# TRAFFIC IMPACT STUDY

**3980 Walker Road  
El Paso County, Colorado**

April 2024

Add pCD file No.  
PPR2350

Figure 7  
TOTAL TRAFFIC - YEAR 2026  
Volumes & Intersection Geometry  
AM / PM Peak Hour  
(ADT) : Average Daily Traffic

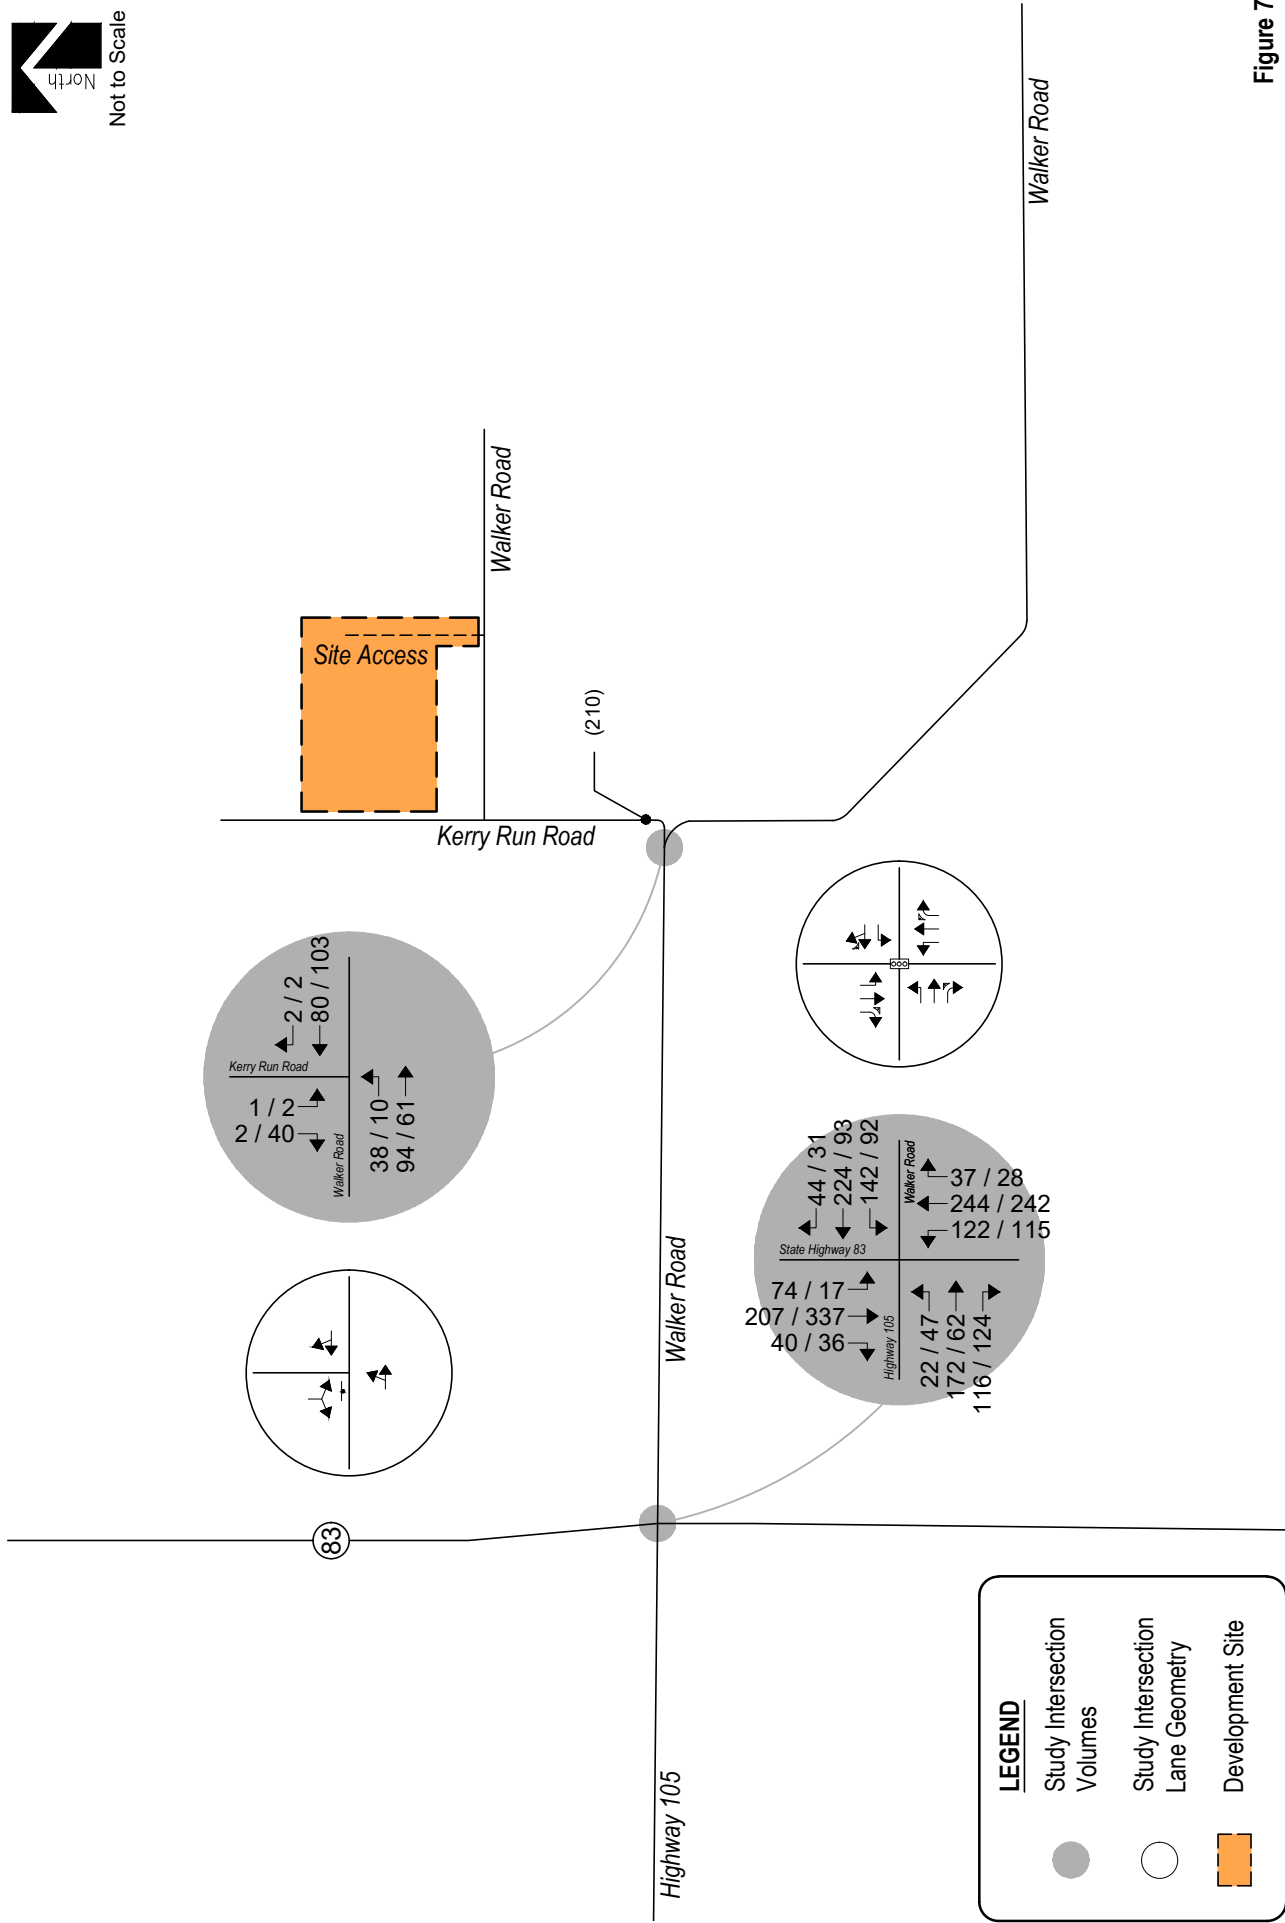
Is the private road up to adequate standard to accommodate the additional traffic generated without an improvements?

Per ECM 2.2.7.B.2 existing roads shall be paved where any development causes an existing gravel road to exceed a projected ADT of 200. Construction drawings for the conversion of Kerry Run from a gravel roadway to a rural paved local roadway and any other improvements will need to be provided.

Per ECM 2.3.7D, thresholds for a dedicated left turn lane at walker road and Kerry run have been met.
